Meadowlake Industrial Park
Filing No. 1 Preliminary Plan
Traffic Impact Study
(LSC #S234040)
September 24, 2023

Add PCD File No. SP236

Meadowlake Industrial Park Filing No. 1 Preliminary Plan Traffic Impact Study

Figure 3
Existing Traffic, Lane Geometry,
Traffic Control, and Level of Service
Meadowlake Industrial Park Filing No. 1 Preliminary Plan (LSC #S234040)

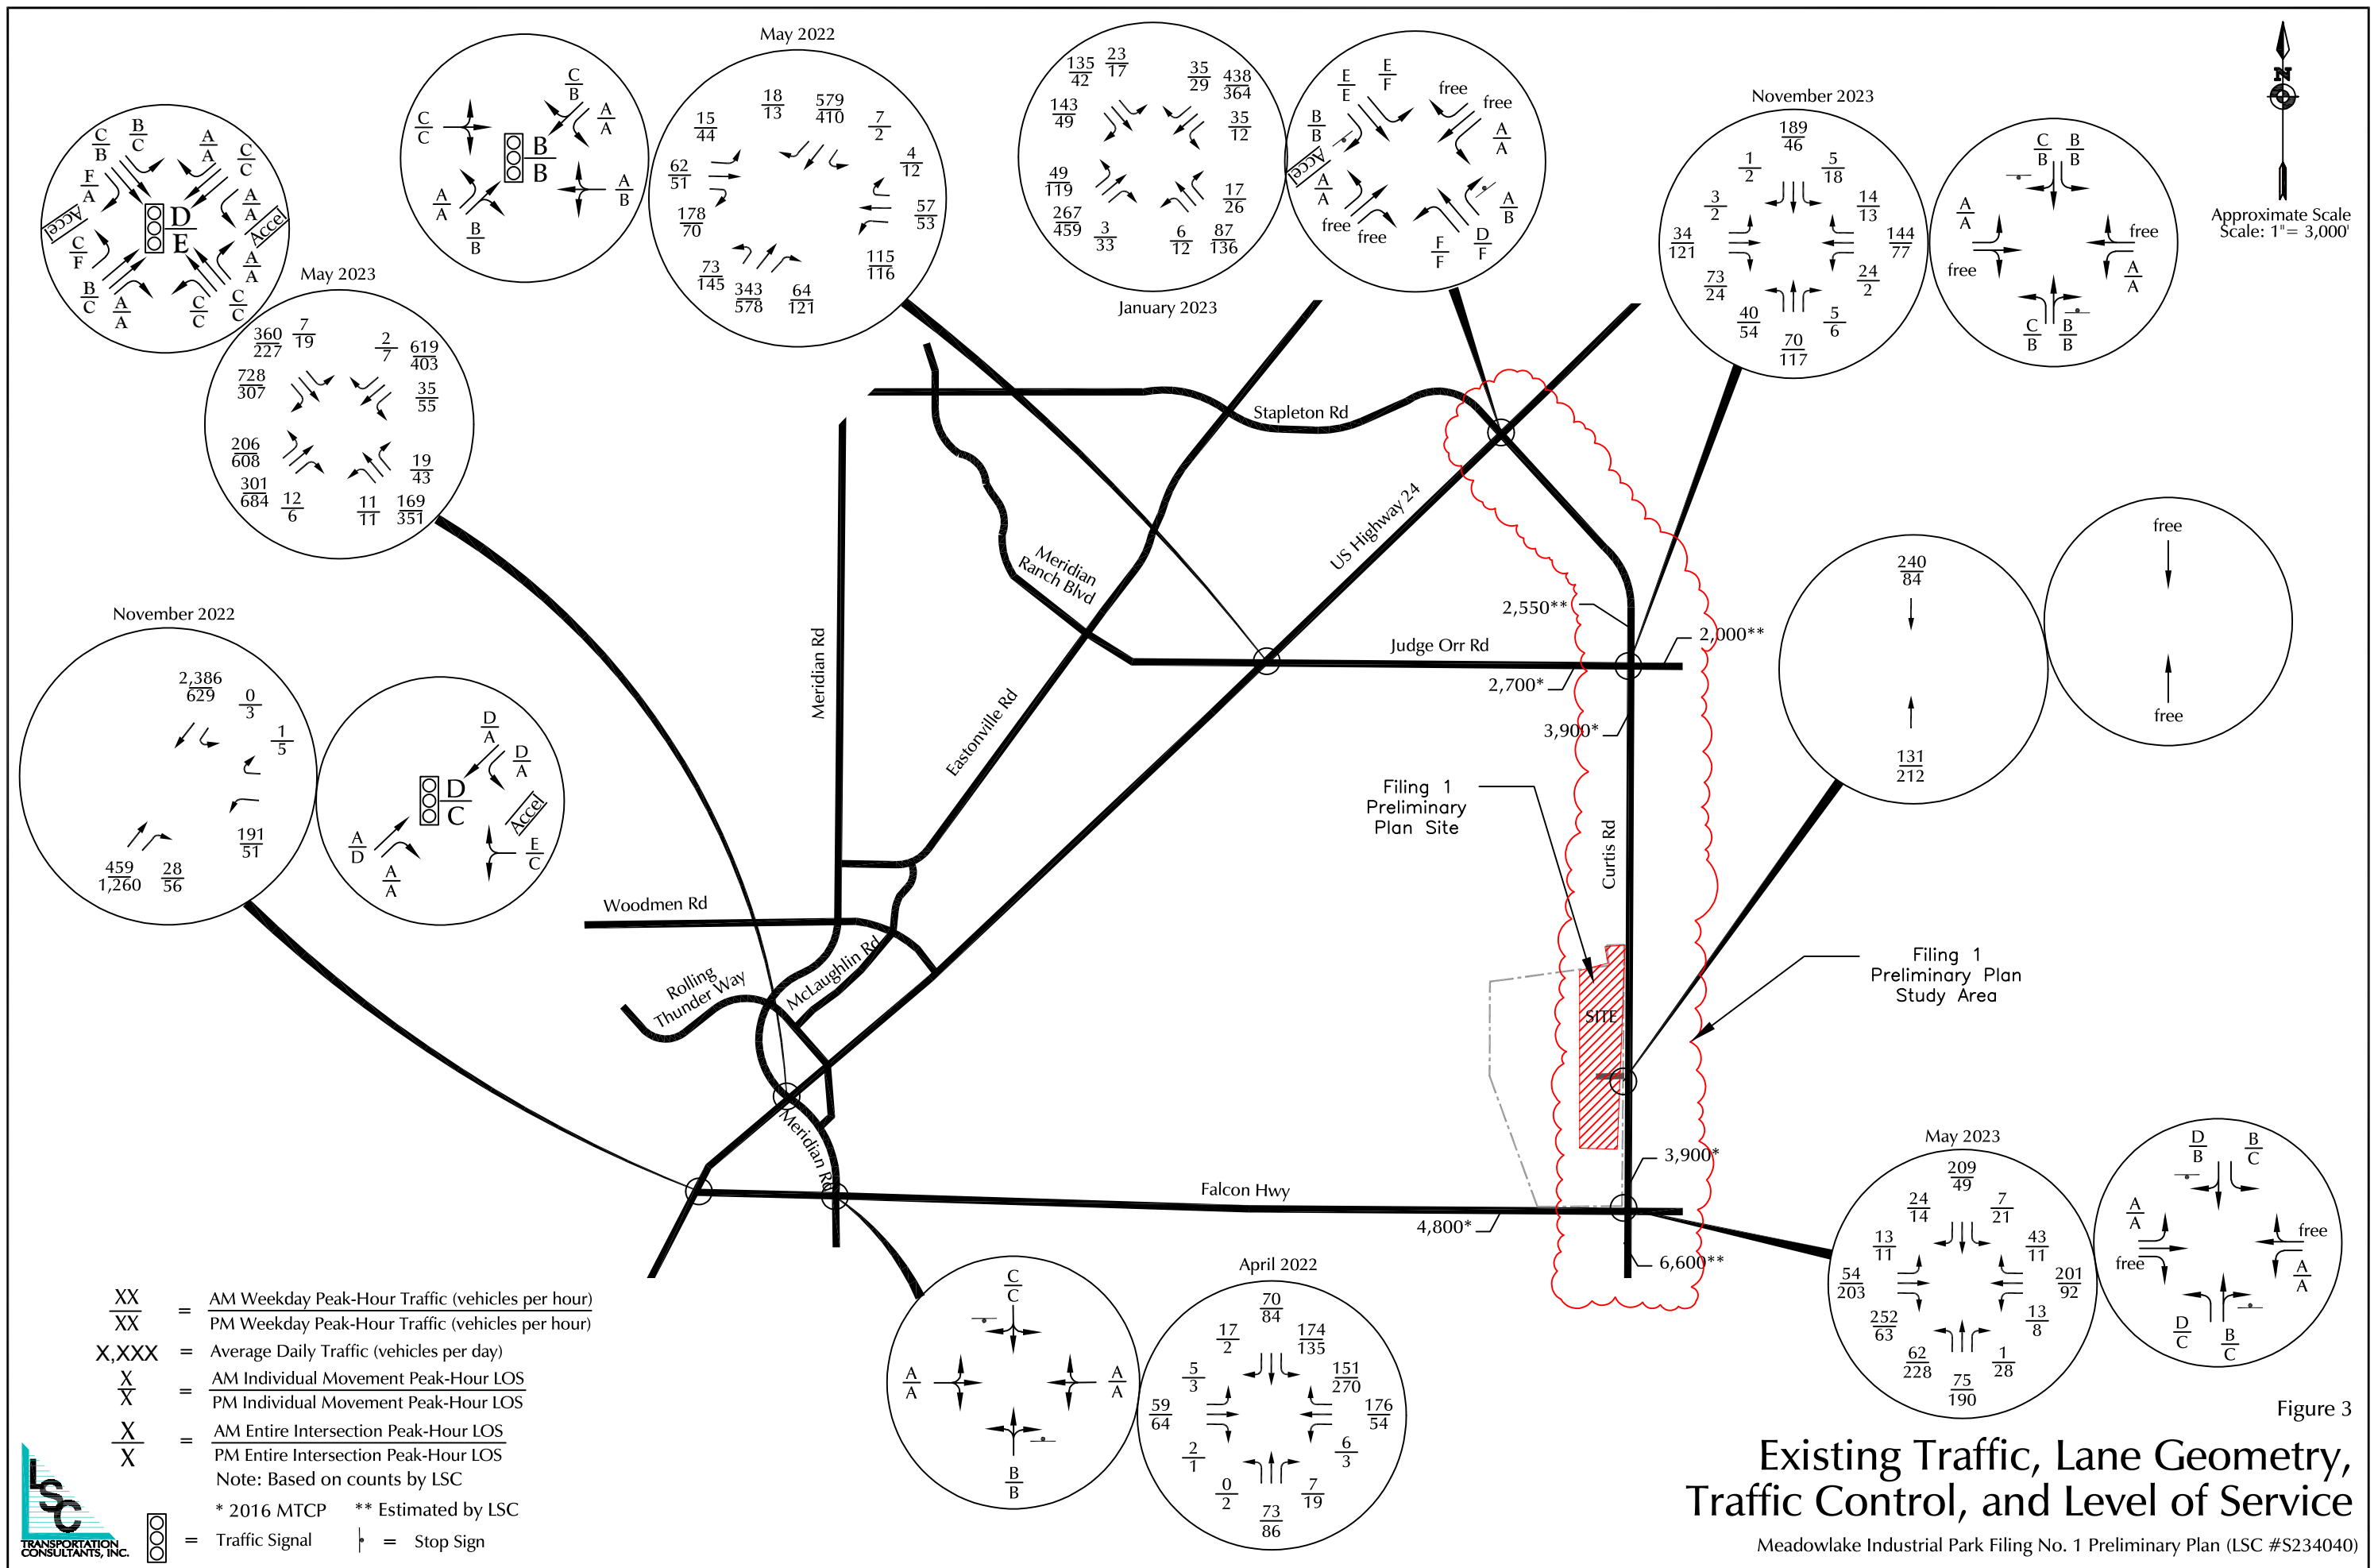
figures 3a & 3b do not provide the LOS. Please verify and update all figures so that they correspond to the correct information indicated in the narrative. Add complete titles to each of the figures so that it is clear what condition is being represented.

Figure 5
Short-Term Site-Generated Traffic
Meadowlake Industrial Park Filing No. 1 Preliminary Plan (LSC #S234040)

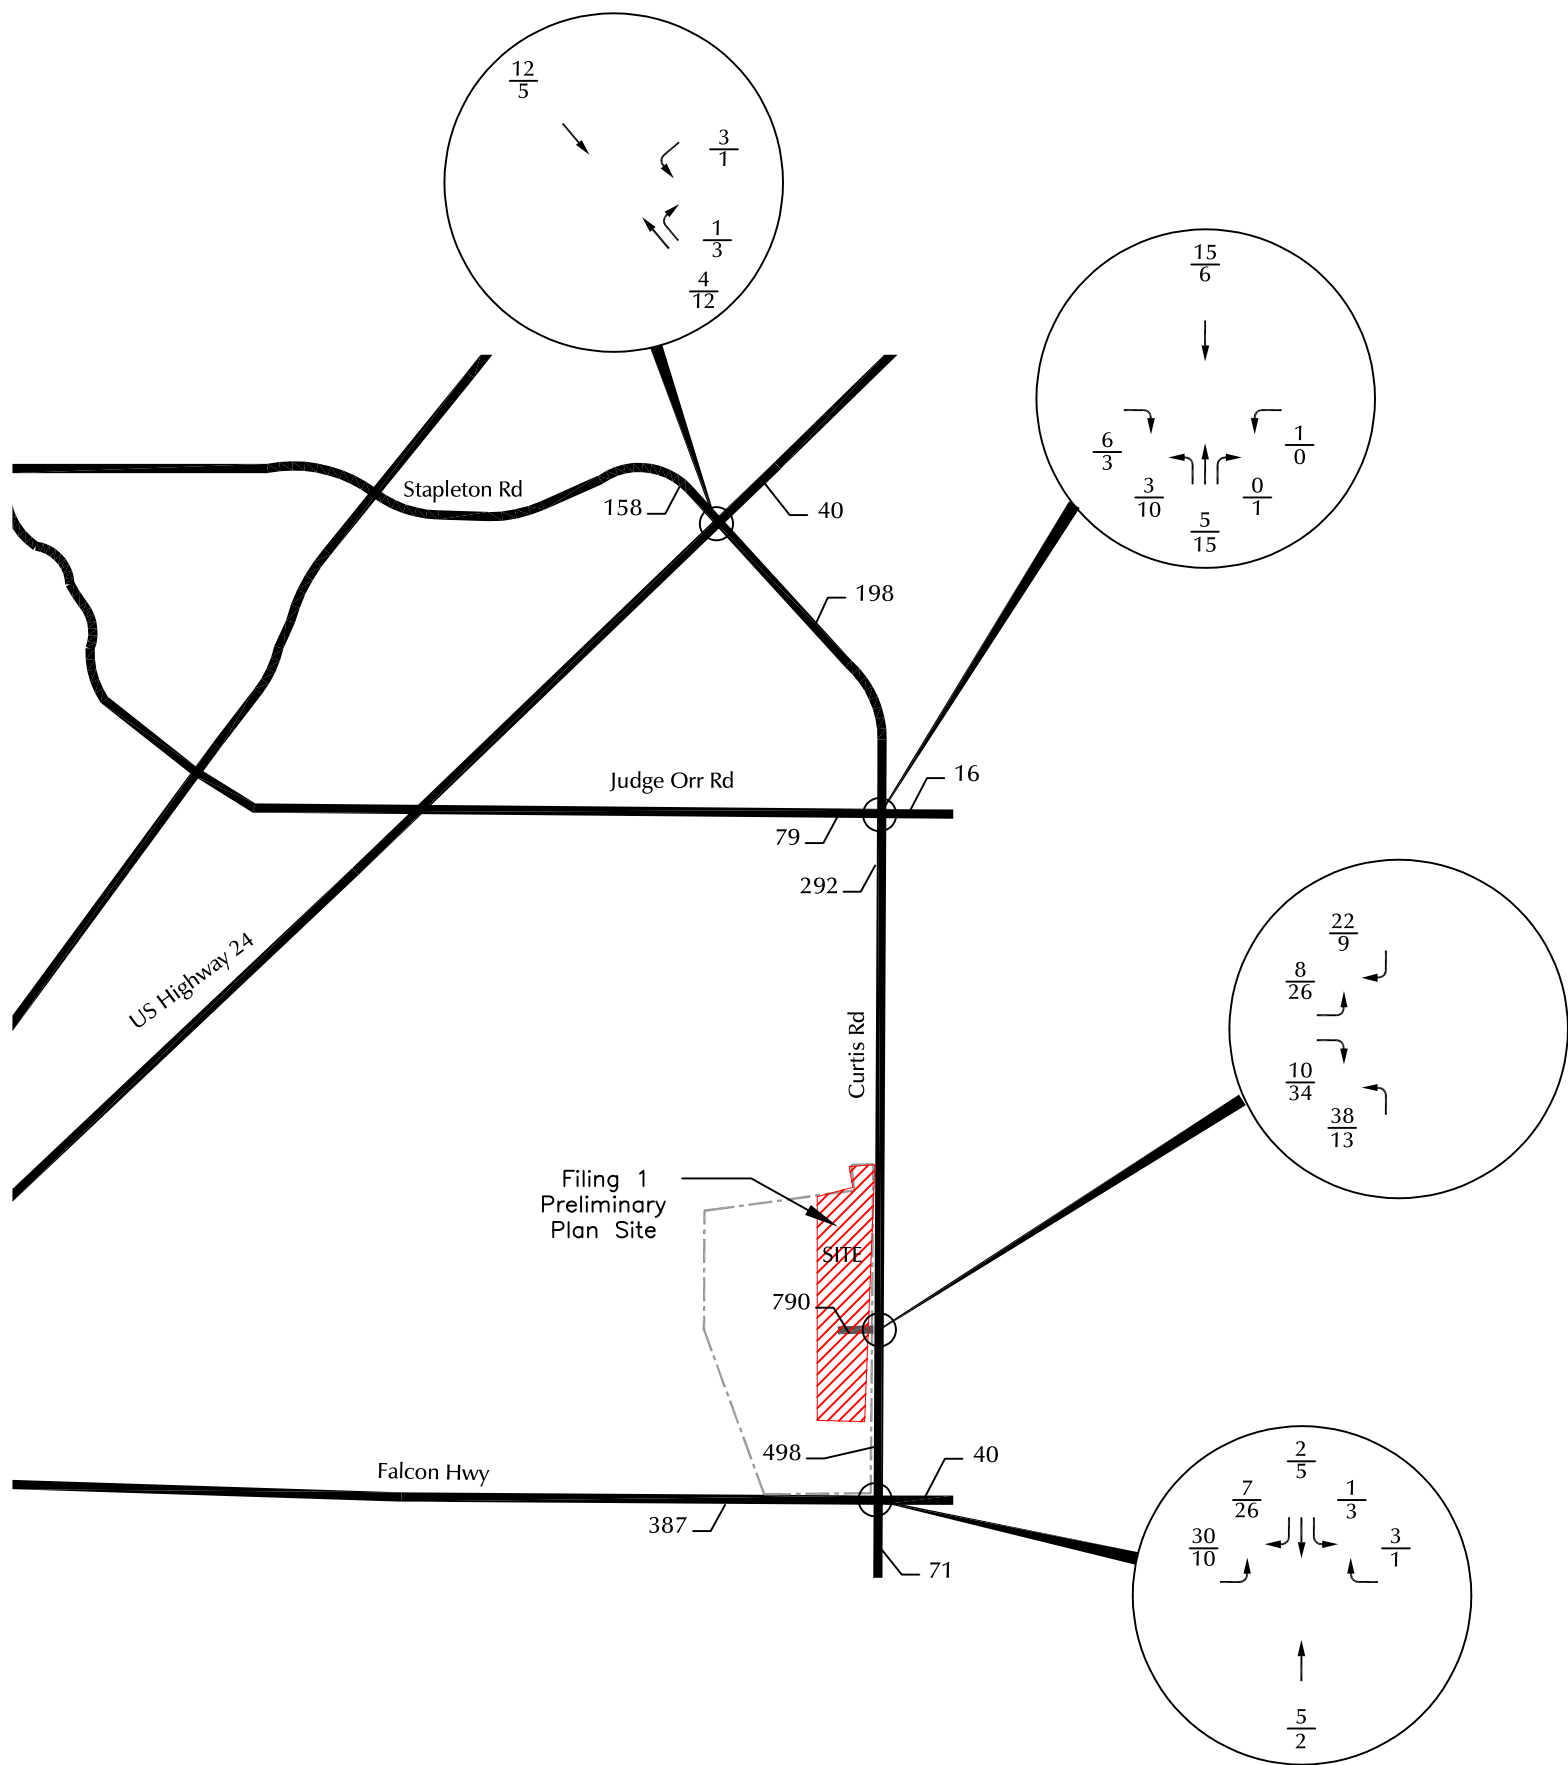
There is no figure 5 in the appendix. Revise to provide figure.

figure 5 has not been provided

Figure 7
**2025 Total Traffic,
 Lane Geometry, Traffic
 Control, and Level of Service**
 Meadowlake Industrial Park Filing No. 1 Preliminary Plan (LSC #S234040)

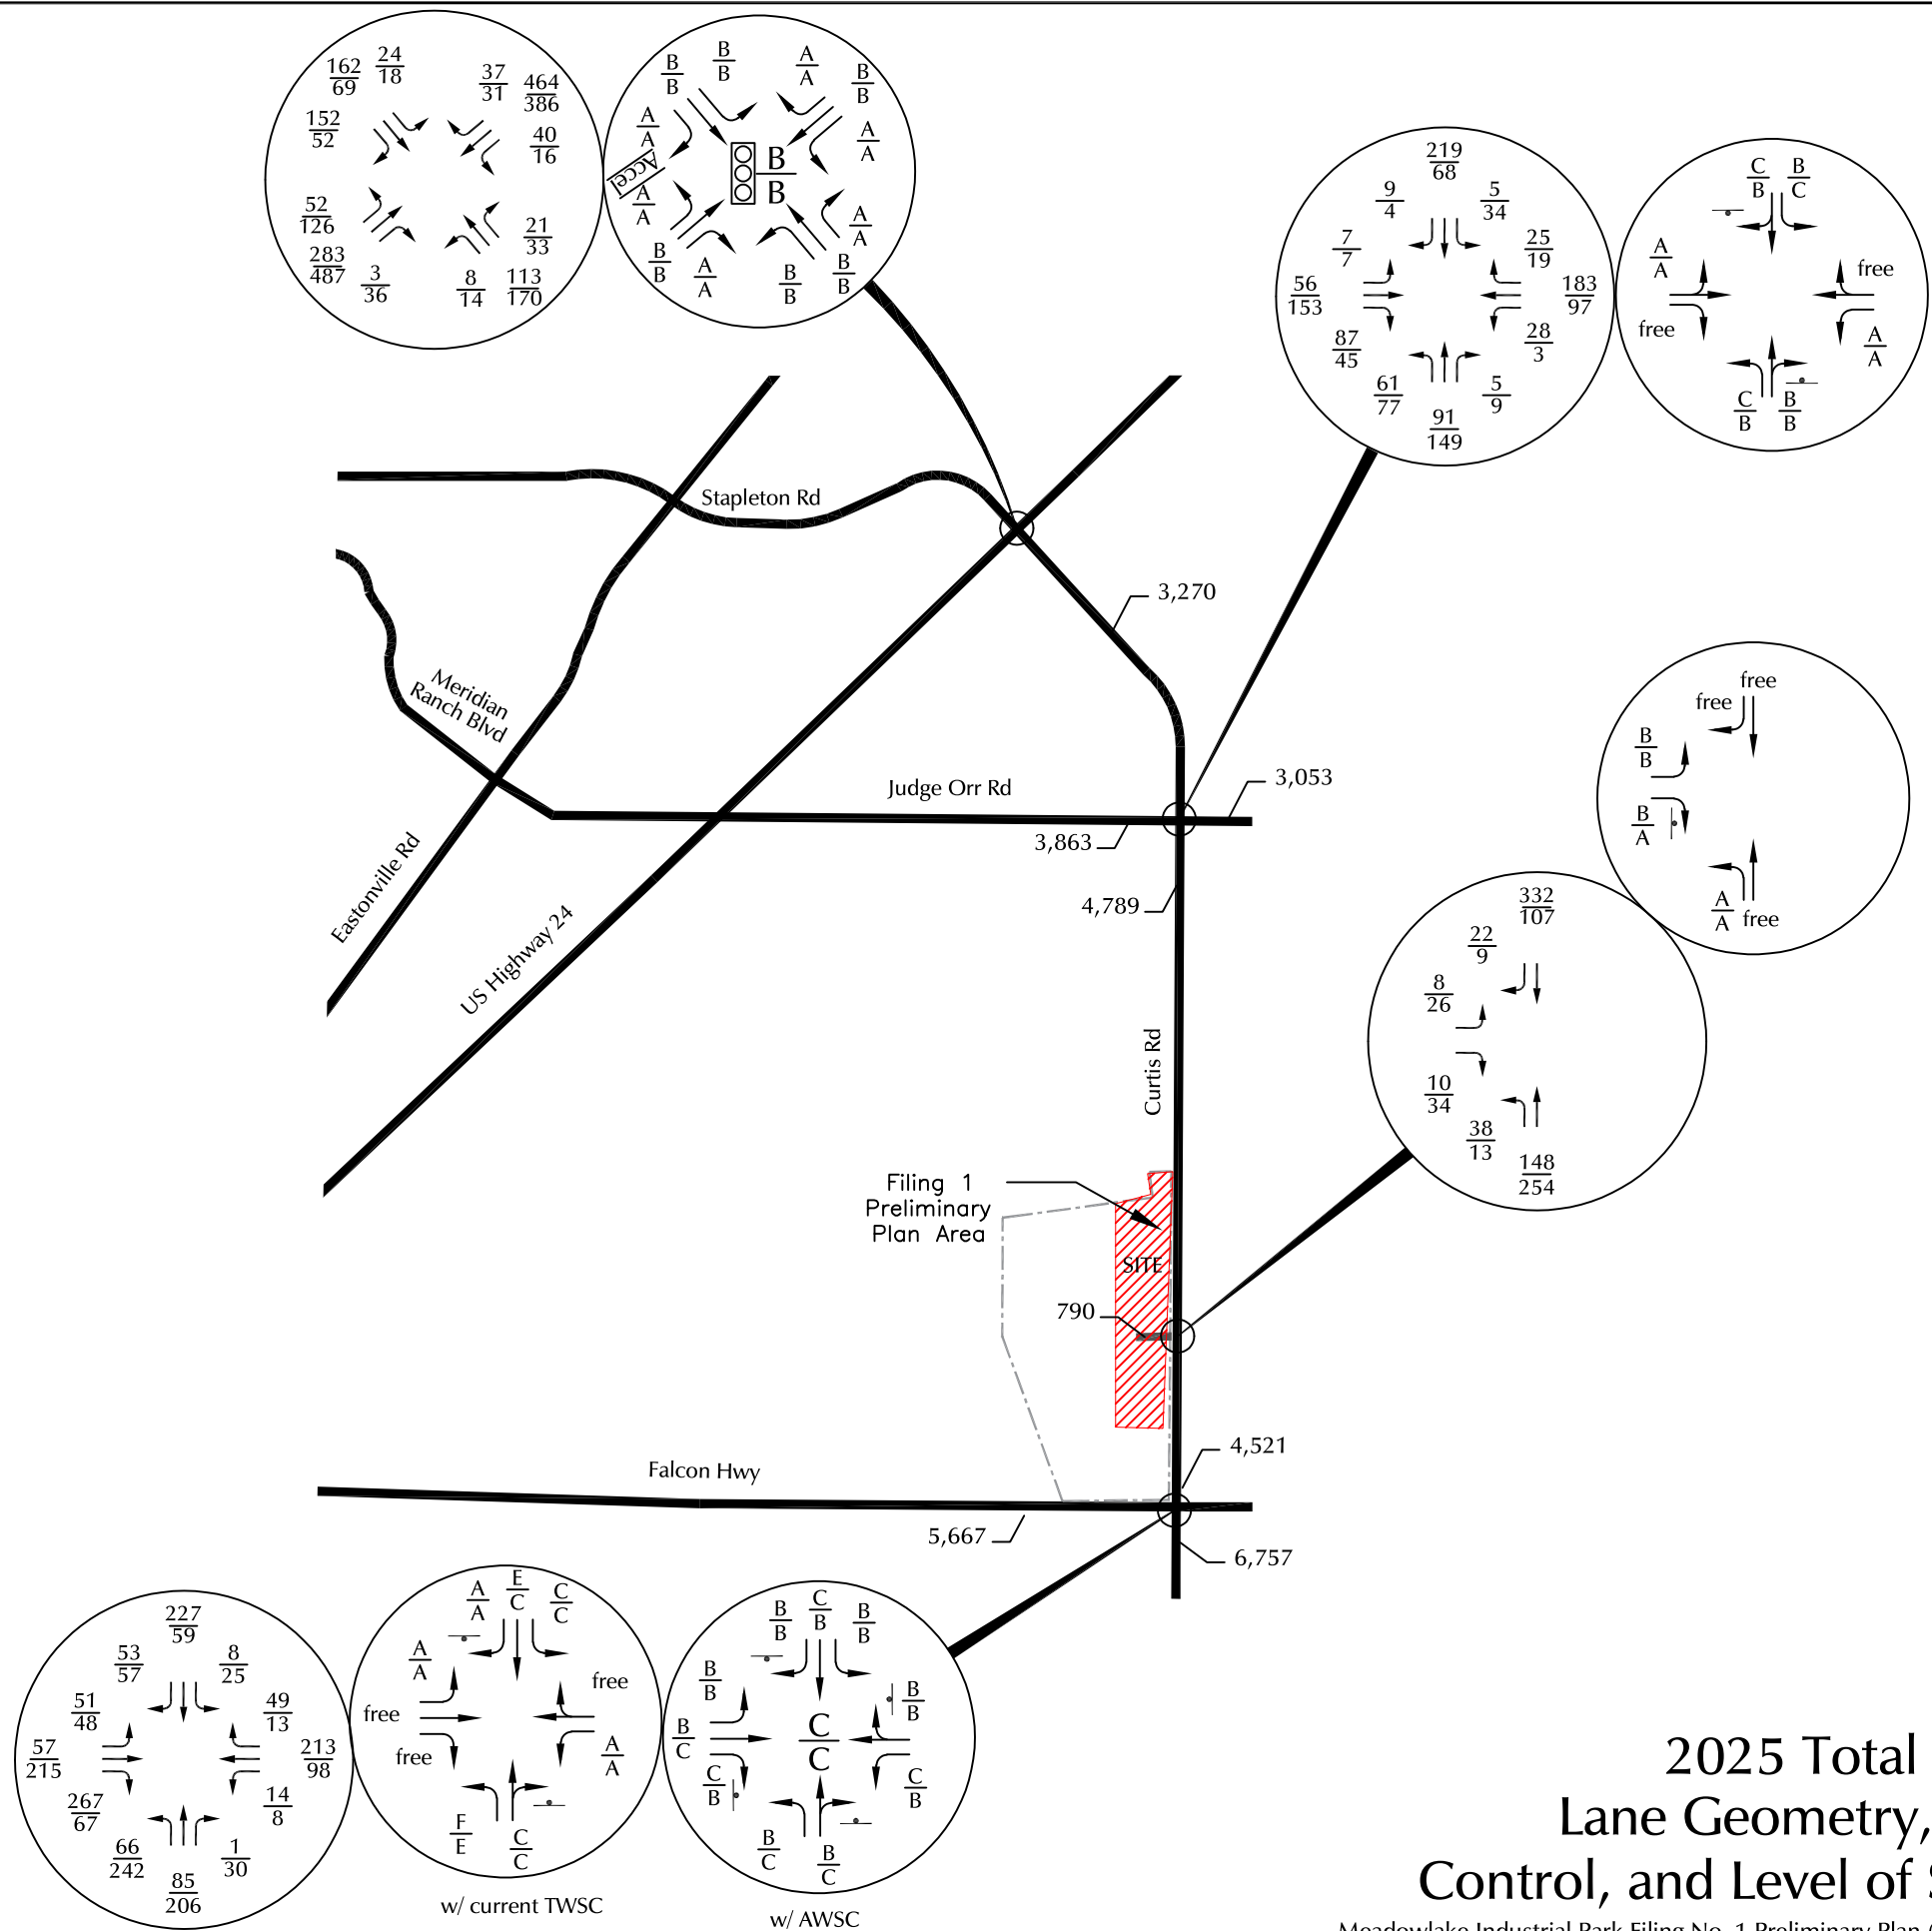
also provide the short term total lane geometry, traffic control and LOS
